Subject: Application BR/178/19/PL

I have recently taken over your application BR/178/19/PL (Delawarr House, Flat 1). I am emailing with a few questions about the proposed plans. In the larger flat the bedroom appears to not have any direct access to daylight. Would there be a possibility of a window in the dressing room? Any information you can give me will be greatly appreciated.

Client	MS SANDY FOTHERGILL-ROBINSON		
Project	PROPOSED FLAT CONVERSION & EXTENSIONS 144 ALDWICK ROAD BOGNOR REGIS WEST SUSSEX PO21 2PA		
Drawing	EXISTING & PROPOSED FLOOR PLANS		
Scale	Date	Drawn	
1:50@A1	29.05.19	TP	
Drawing No.	Revision

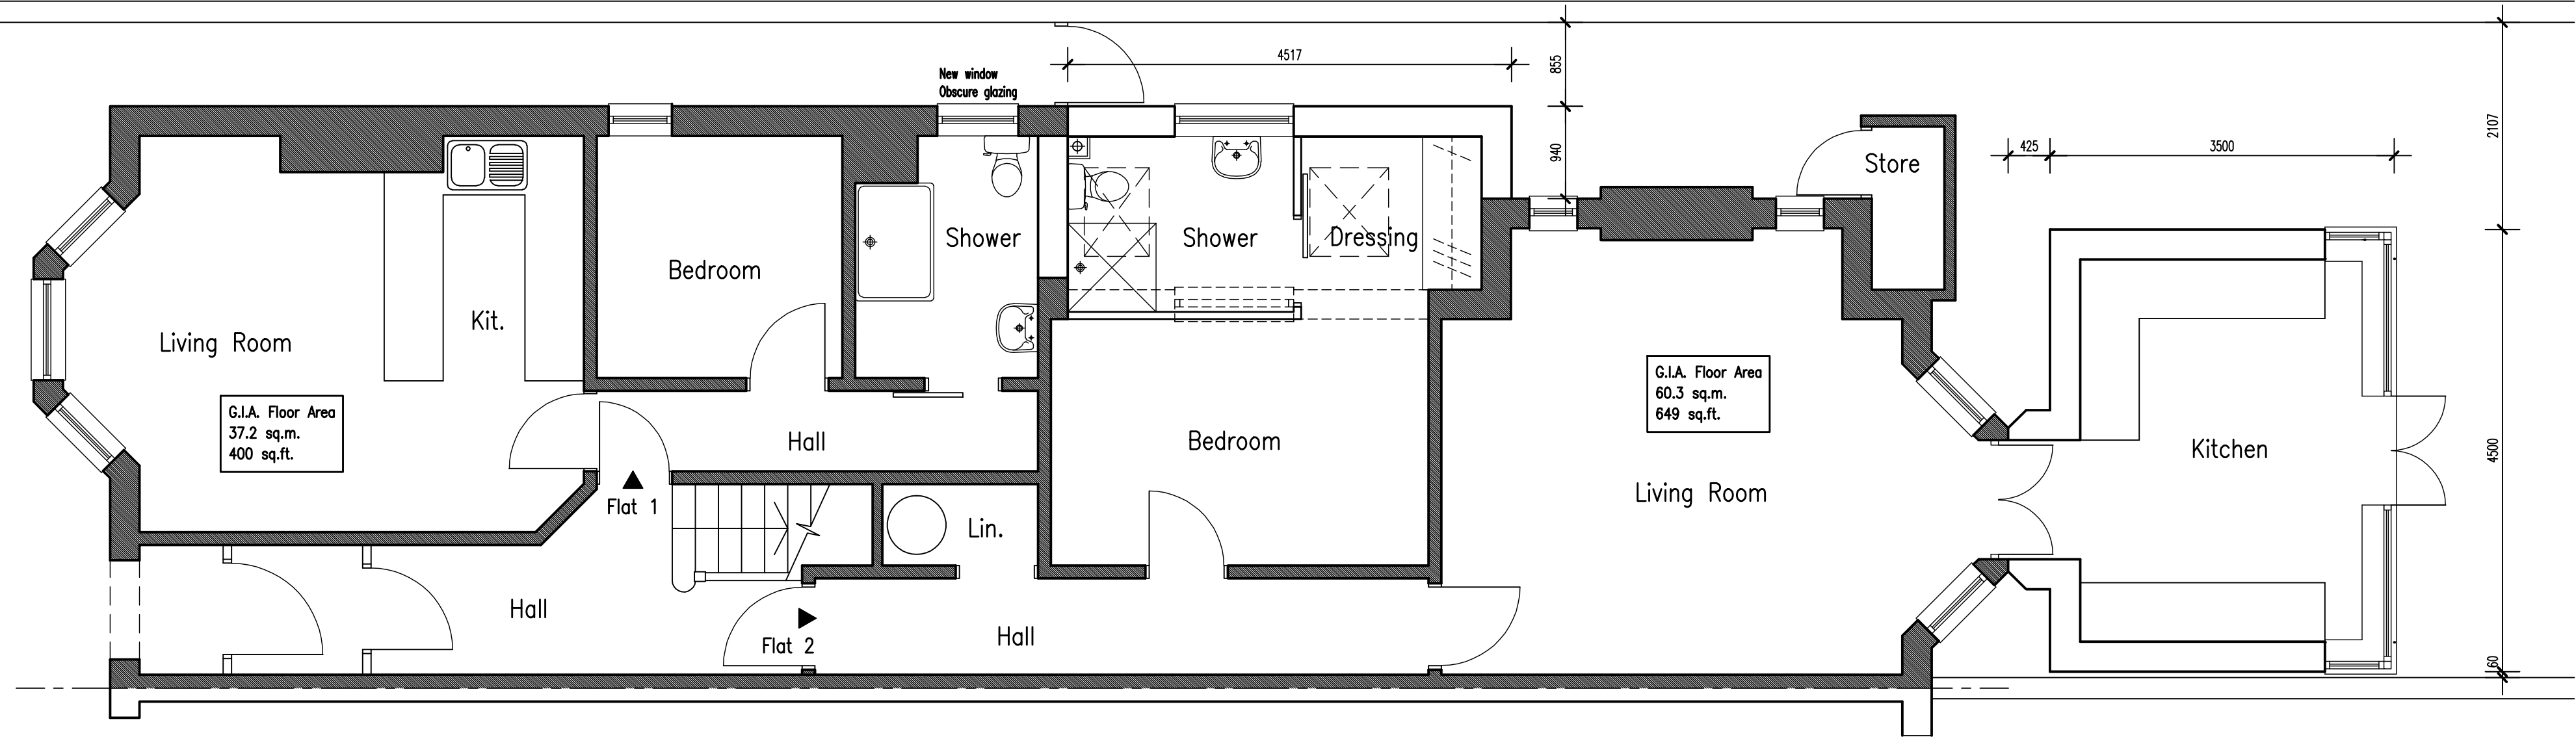
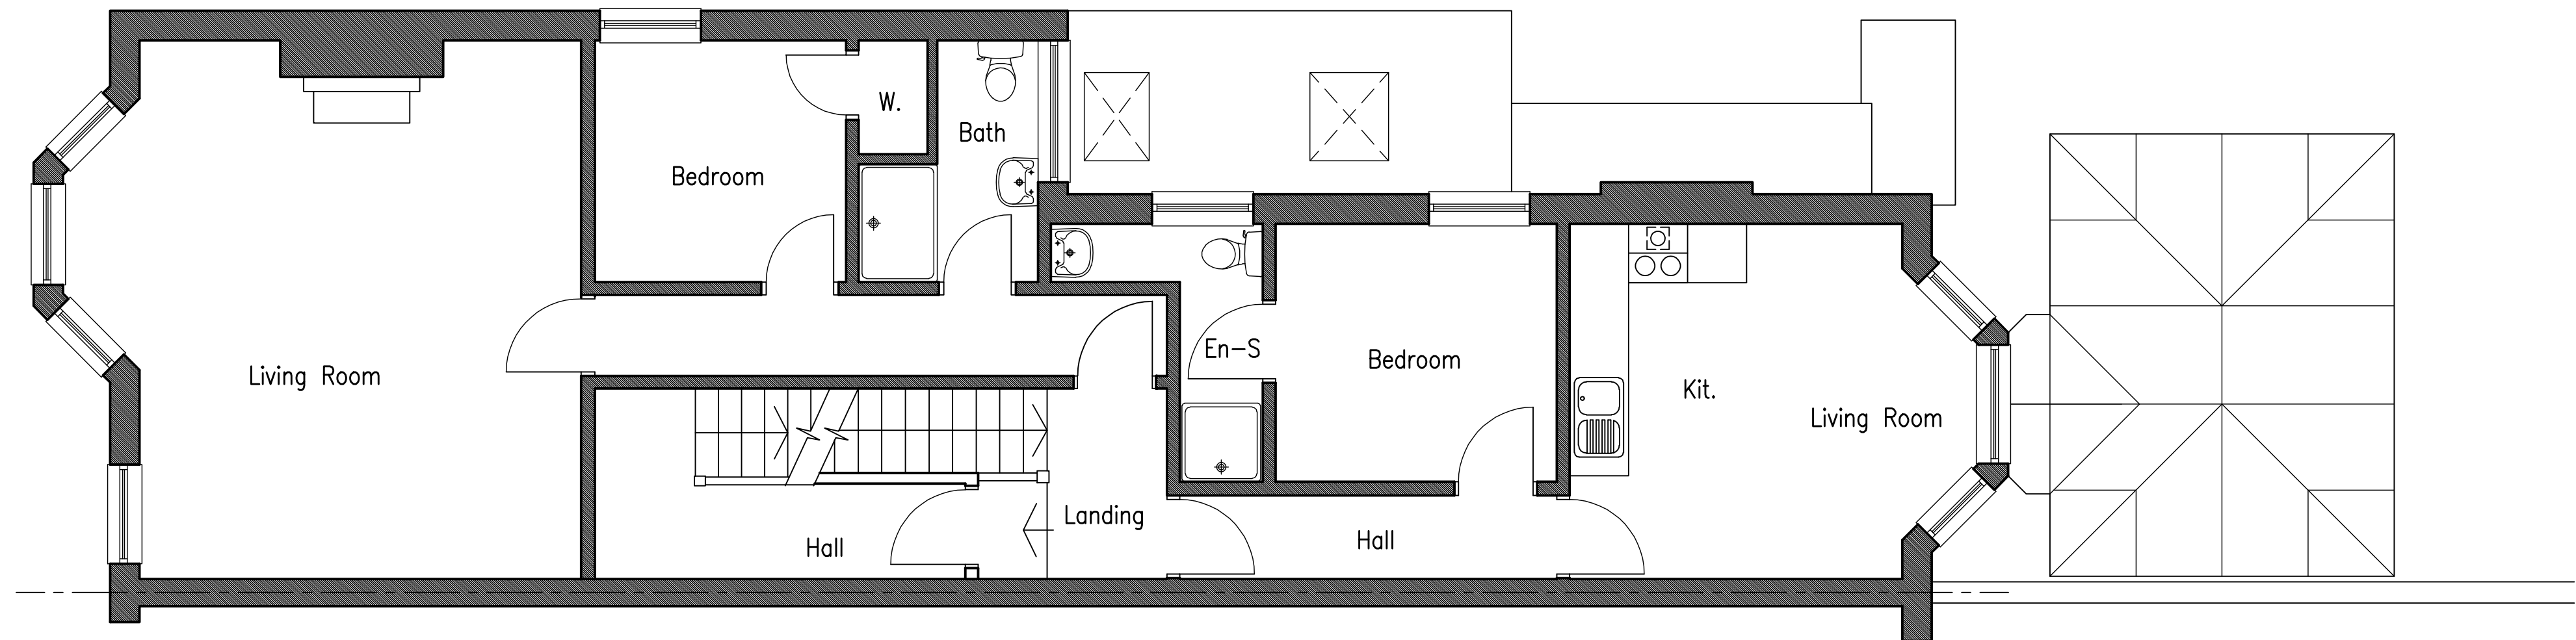
The issue that we find with the sky light is that it is not direct light into the bedroom, the way we would see to overcome this is to have a window in the dressing room, is this a possibility?

Further to your earlier e-mail please find attached amended planning drawings showing an additional window to the side extension bedroom as requested.

Further to your e-mail below I can confirm that the plans currently show a roof light to dressing room. I have attached the floor plans and elevations for your information.
